From: Nicola Spencer on behalf of Planning
Sent: 14 February 2018 08:49
To: Planning.Responses; Planning Scanning
Subject: FW: WA/84/17/PL Fairmeads ' Farm '.

WA/84/17/PL - Fairmeads 'Farm'.

**SITE LOCATION PLAN
AREA 16 HA
SCALE 1:2500 on A4
CENTRE COORDINATES: 499314, 105496**

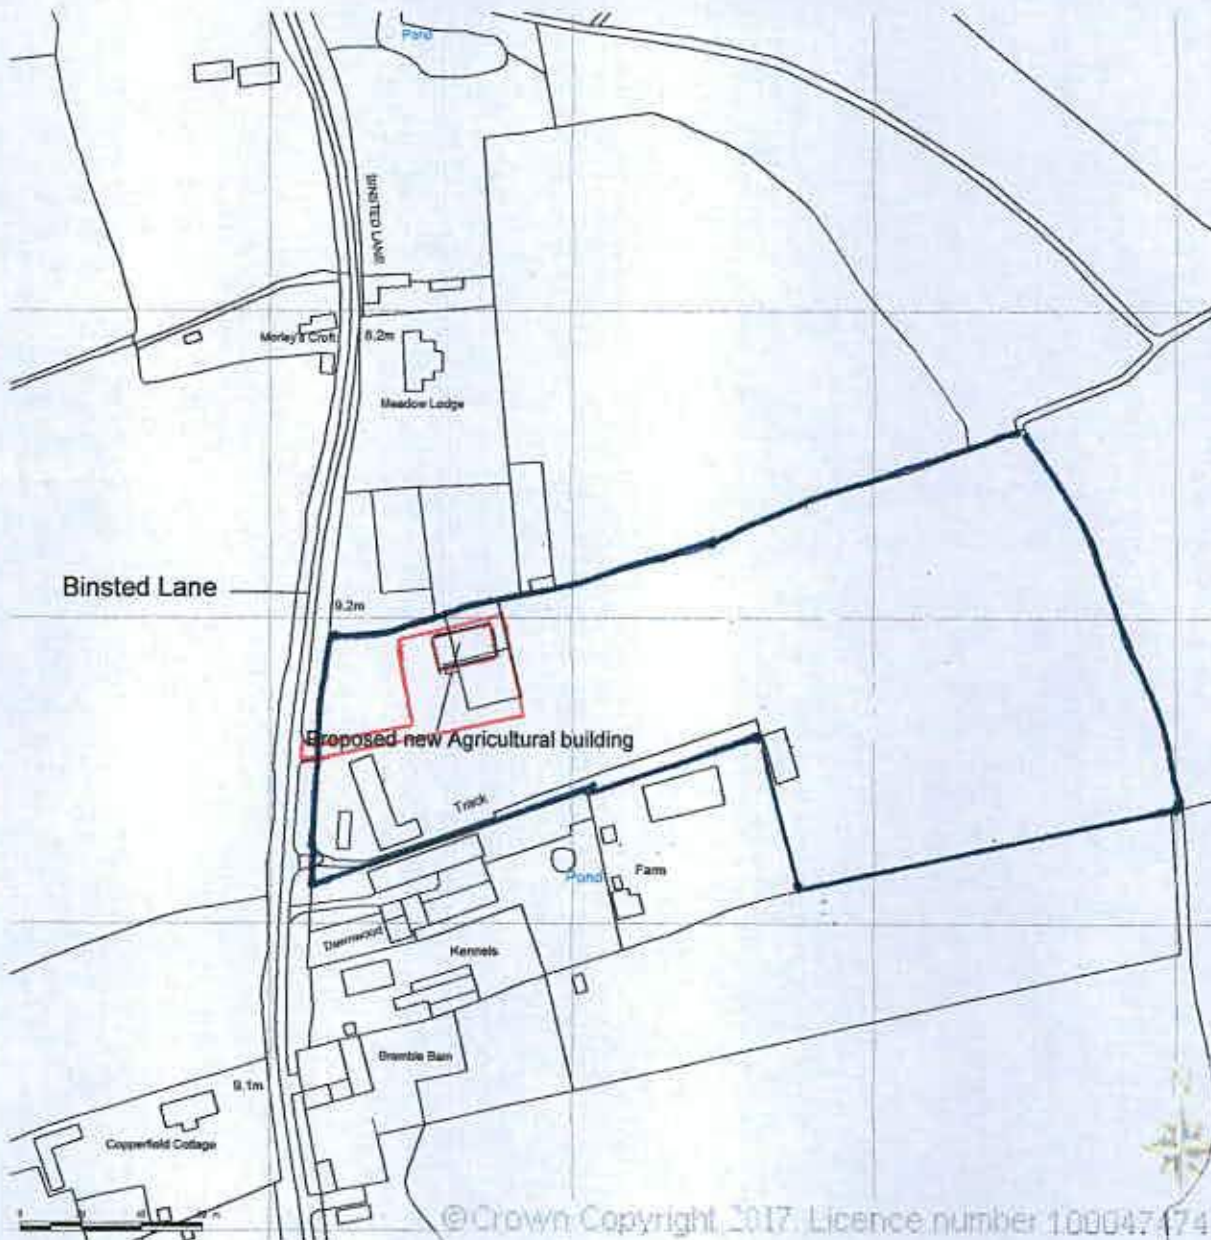
1. One of the Design and Access statements submitted in support of the application is headed "16 HA". Is this intended to mislead the reader to believe the site is 16 Hectares?
2. Para 18 of the application states that the non residential floor space of the proposed building will be 293.5 m2. The plans of the proposed building show a floor space of 190m2.

Drag No RA/671/500 BLOCK PLAN rev 1

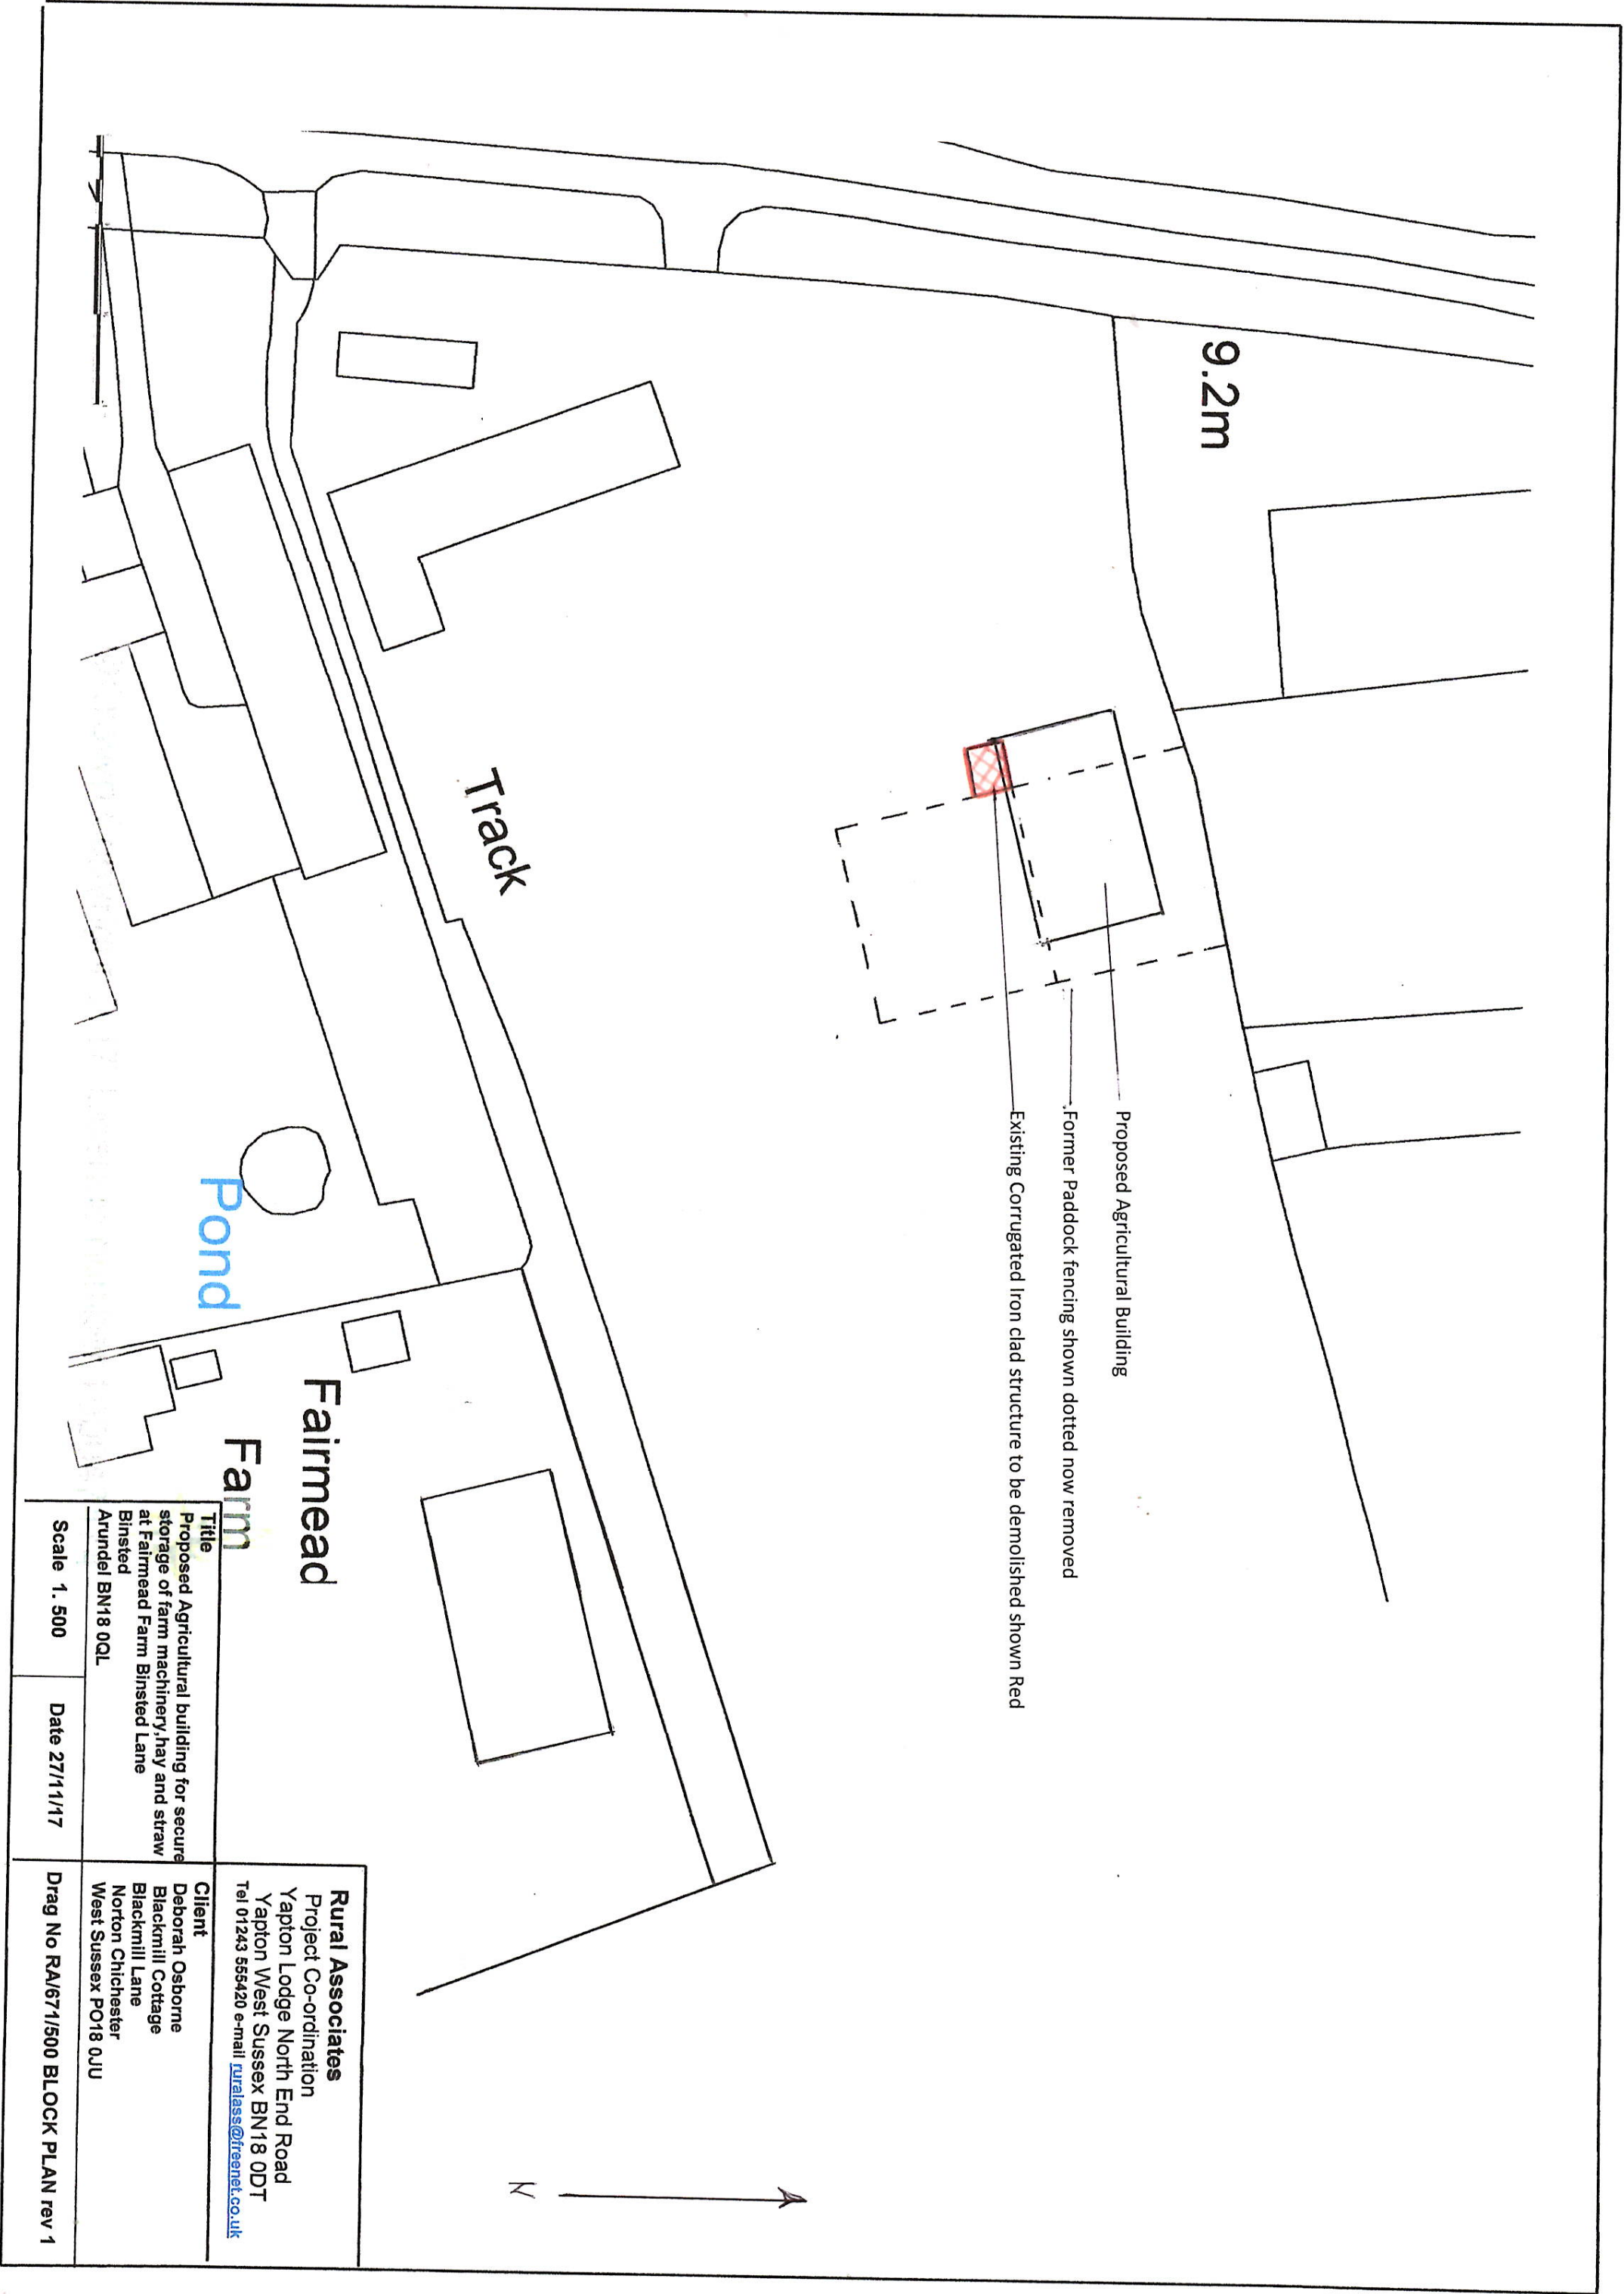
The Block Plan dated 27/1/18 RA671/500/Rev 1 published on 5/2/18 further perpetuates the misrepresentation made previously that there is/was a "paddock" in the location claimed by the dotted lines by stating " former paddock fencing shown dotted now removed ".

I have lived in Binsted in proximity to the site since 1994 and since that date there has never been any "paddock" as the Applicant is trying to suggest. If there is any evidence of any "structure" existing prior to that date it would be helpful if it could be produced. This historical fact has already been confirmed by Darren Mills.
